Derek Parody
A303 Stonehenge Project Director
Highways England
Temple Quay House
2 The Square
Temple Quay
Bristol BS1 6HA

**A303 Amesbury to Berwick Down
Application for Development Consent
Applicant's intention to submit a request for proposed scheme changes**

Drawing Title
**RIGHTS OF WAY AND ACCESS
PLANS
REGULATION 5(2)(k) & 5(2)(o)
SHEET 8 OF 15**

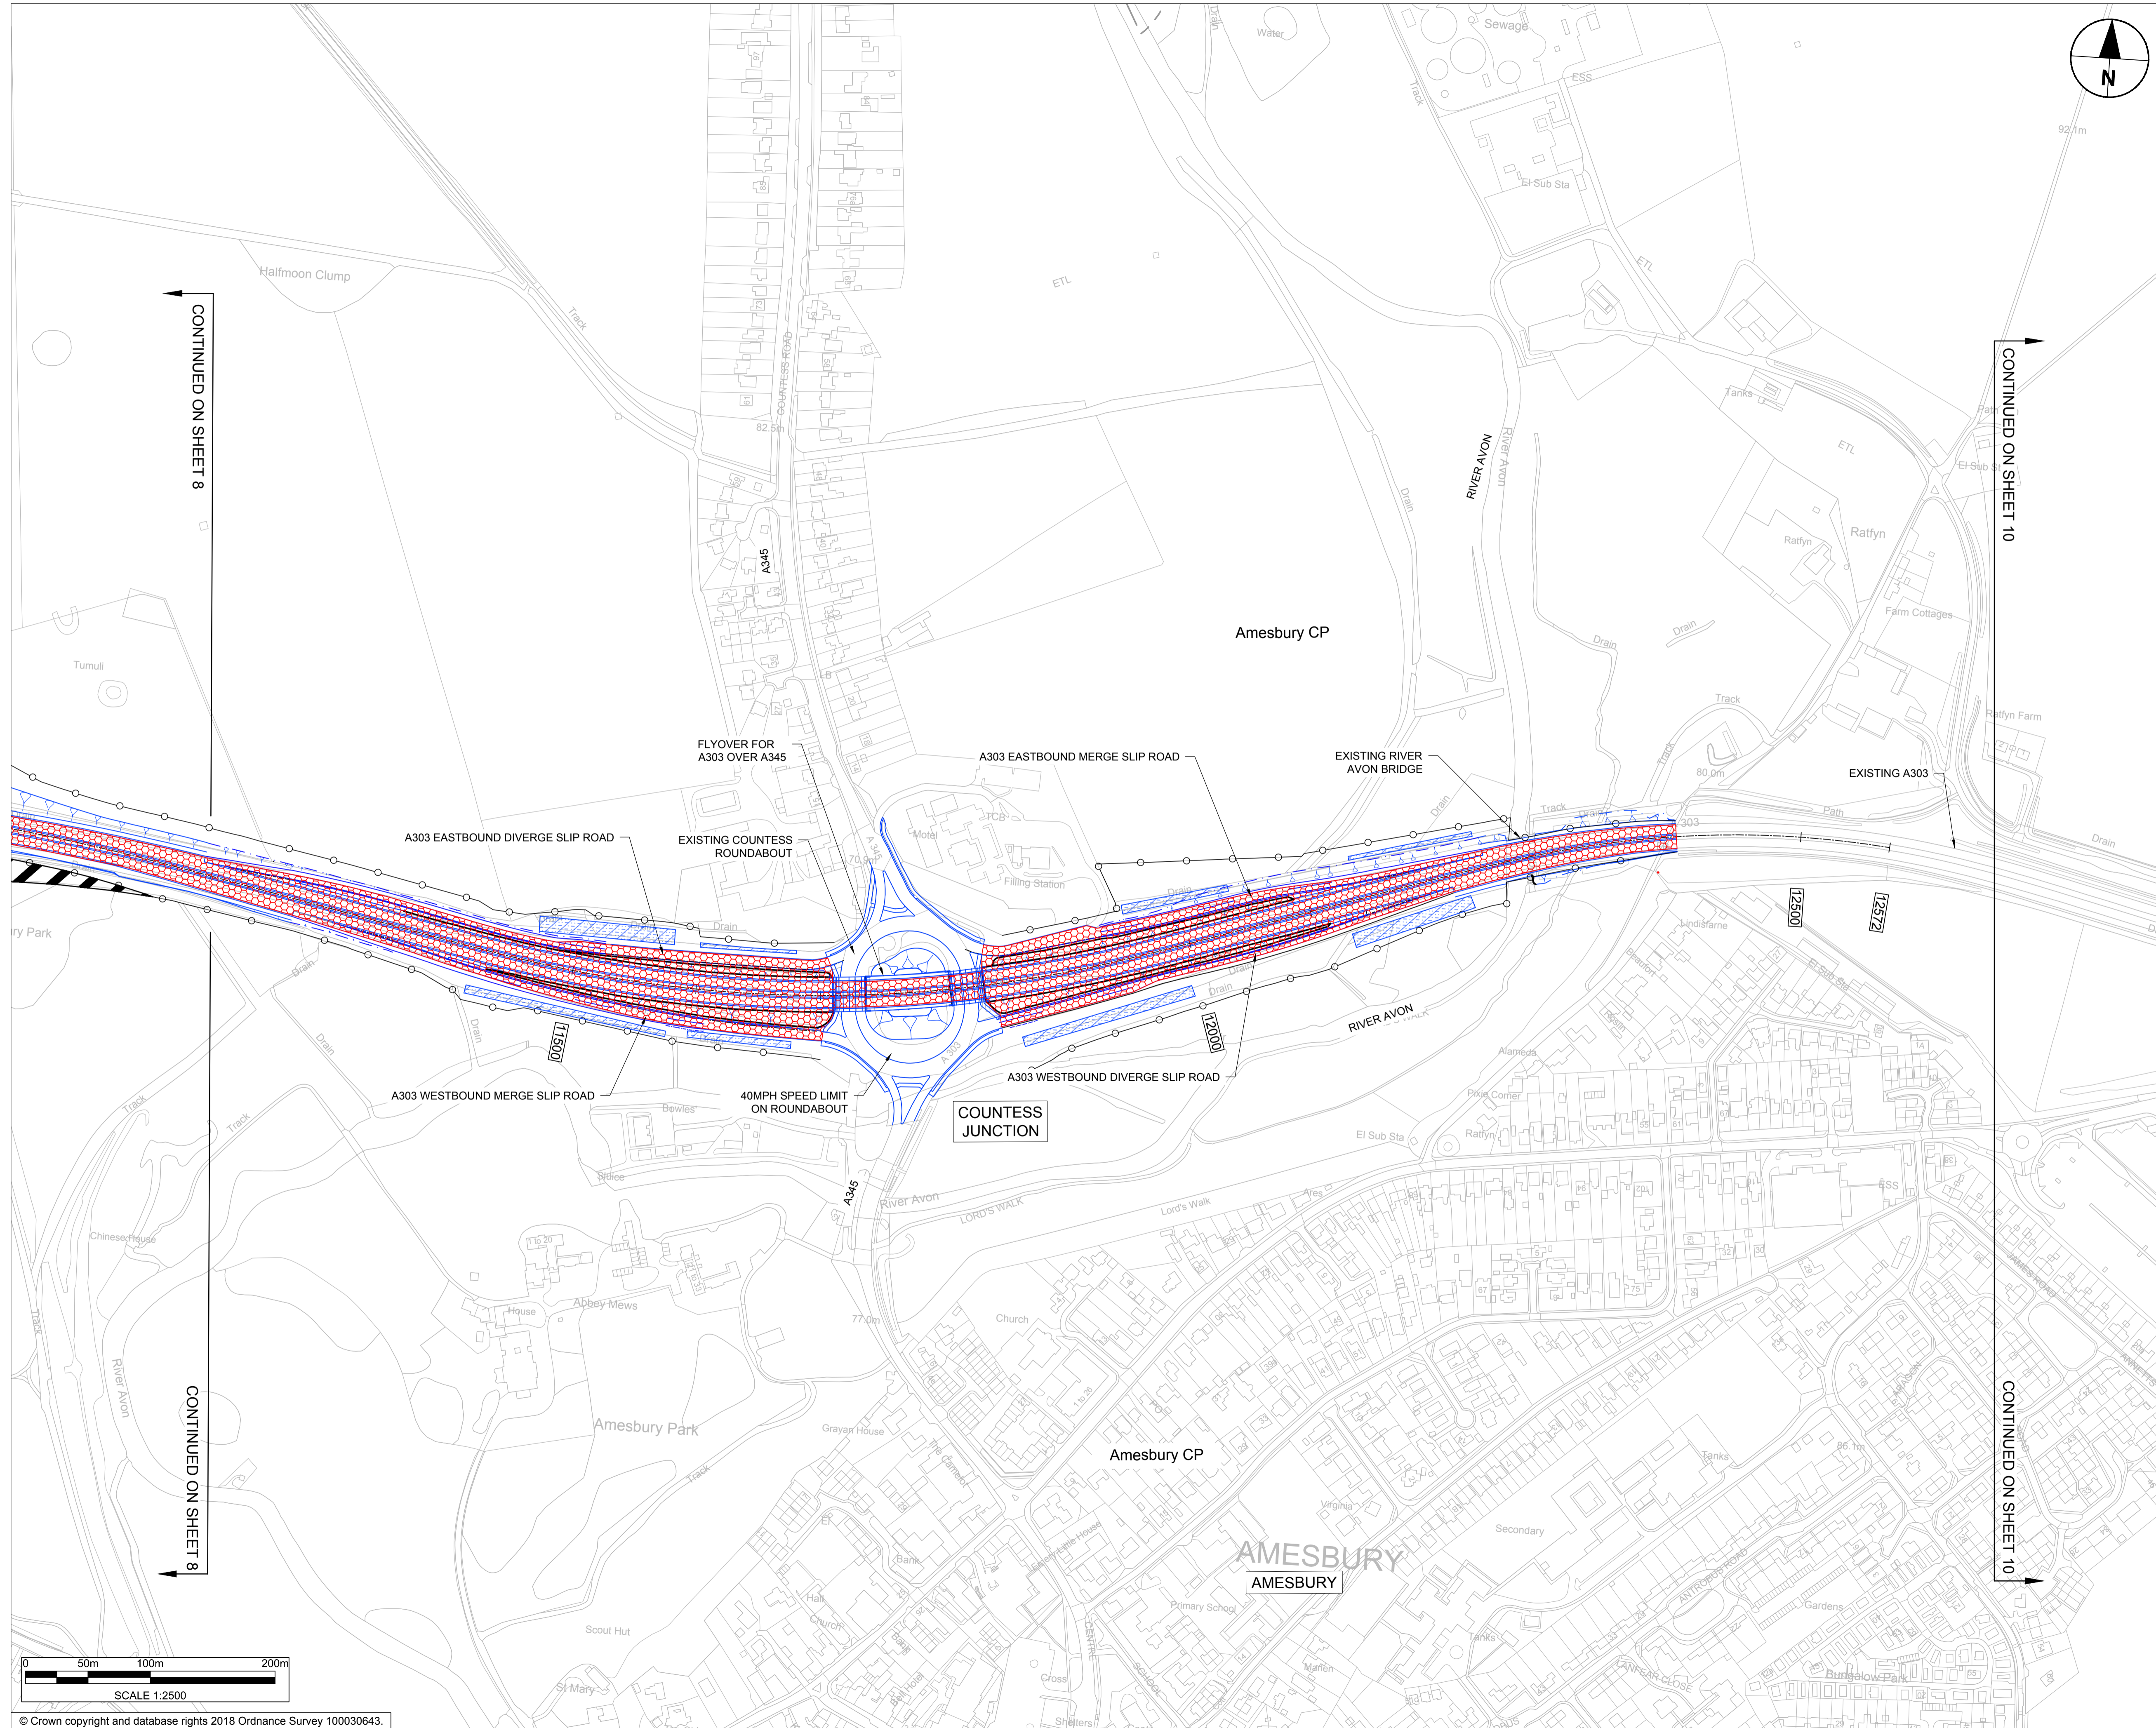
32. The Application does not include provision for a turning head on Stonehenge Road to facilitate vehicle turning movements immediately south-east of the point at which Stonehenge Road is proposed to be converted to a new restricted byway – see Reference J on Sheet 8 of the Rights of Way and Access Plans [APP-009]. As Stonehenge Road will become a cul-de-sac for motorised vehicles travelling north-west, which do not have private means of access rights to continue towards Stonehenge Cottages, the Applicant considers it appropriate to provide a turning head at this location.

33. Accordingly, the Applicant proposes to modify the highway layout to incorporate a turning head within the Order limits and within the existing highway boundary, immediately south-east of the terminus of the proposed restricted byway Reference J.

Drawing Title: **RIGHTS OF WAY AND ACCESS PLANS REGULATION 5(2)(k) & 5(2)(o) SHEET 14 OF 15**

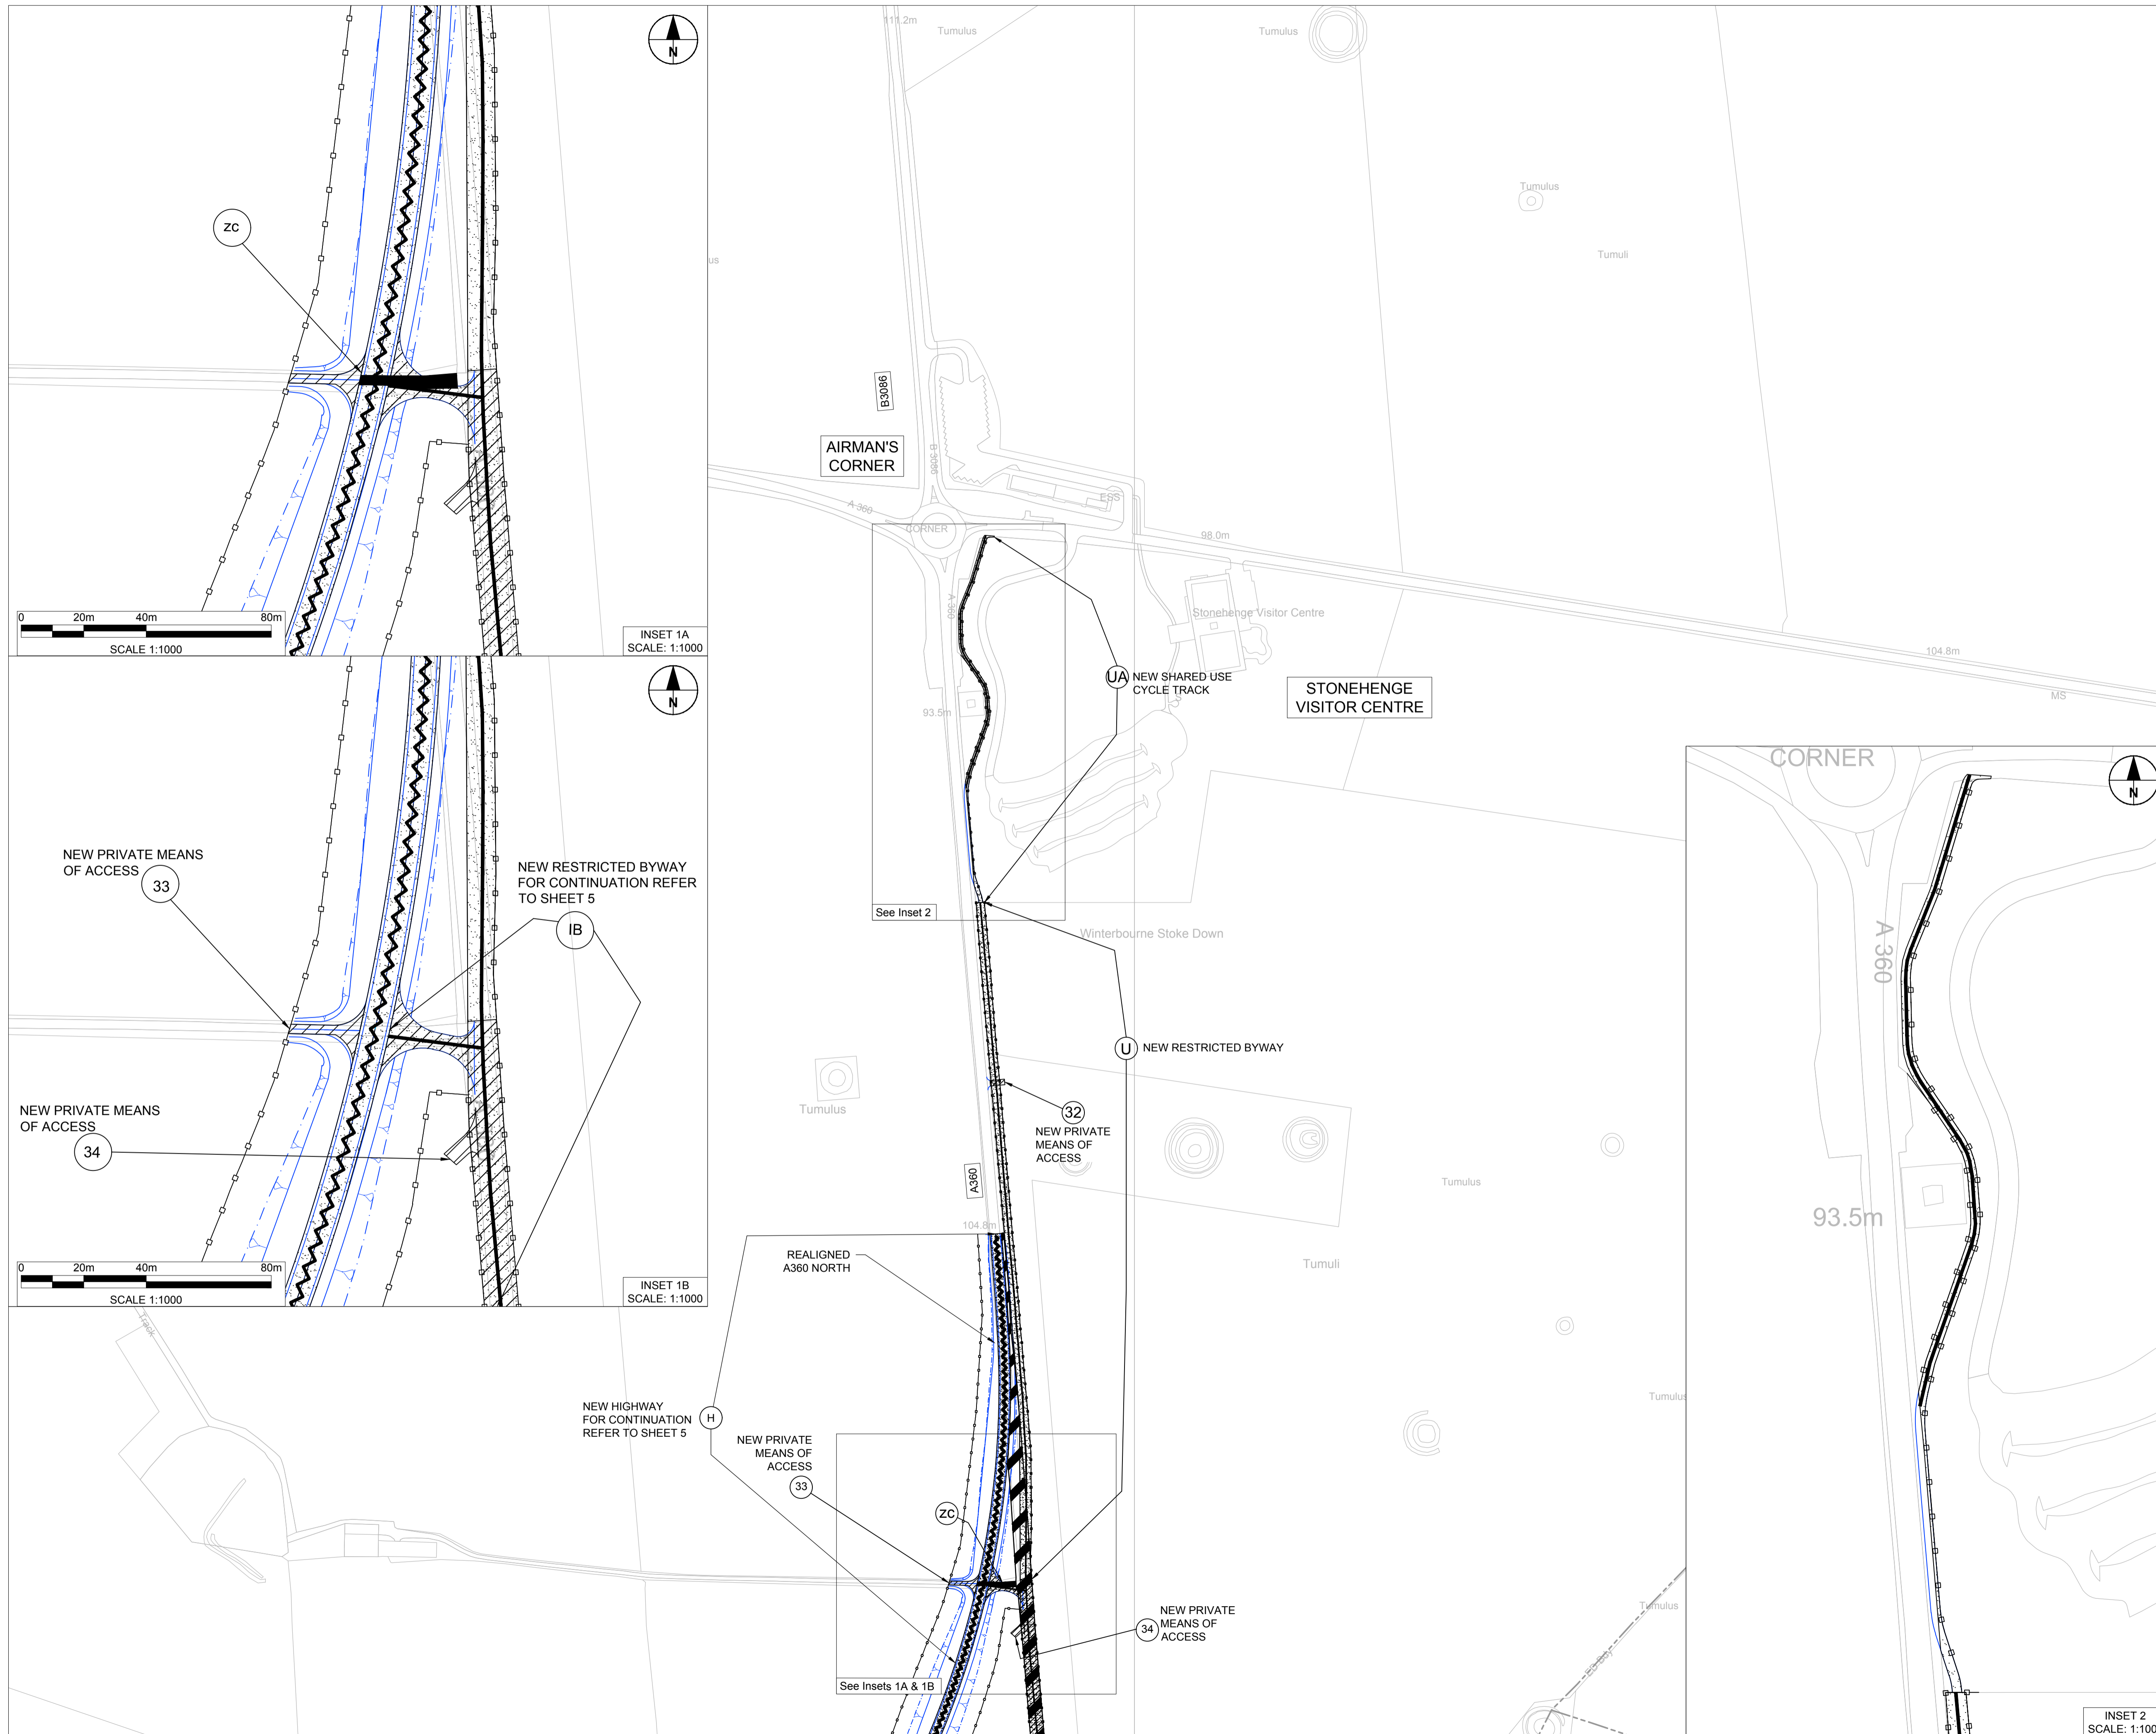
36. As set out in the Applicant's Comments on Written Representations [REP3-013] at paragraph 43.1.18, an alternative arrangement has been suggested for the link opposite Kighton Track between the proposed A360 and the new restricted byway Reference U, on the line of existing private means of access Reference zc (currently proposed to be stopped up and replaced by new private means of access Reference 33). These references are shown on the Rights of Way and Access Plans [APP-009], on Sheet 14.

40. For the reasons set out in the Applicant's Comments on Written Representations [REP3-013] (paragraphs 28.4.1 to 28.4.3 refer) and subject to continuing discussions with the affected landowner and English Heritage, the Applicant proposes to amend the route

and possibly the status of the new public right of way comprised in References U and UA as shown on the Rights of Way and Access Plans [APP-009] (on Sheet 14) and identified in Schedule 3 to the draft Development Consent Order [REP3-003]. This route is the proposed restricted byway which would run from a point opposite Kighton Track northwards to the former A344 at Stonehenge Visitor Centre.

37. The Applicant, having undertaken further design work to establish the feasibility of the proposed alternative arrangement, proposes to move this link northwards by approximately 15 metres.
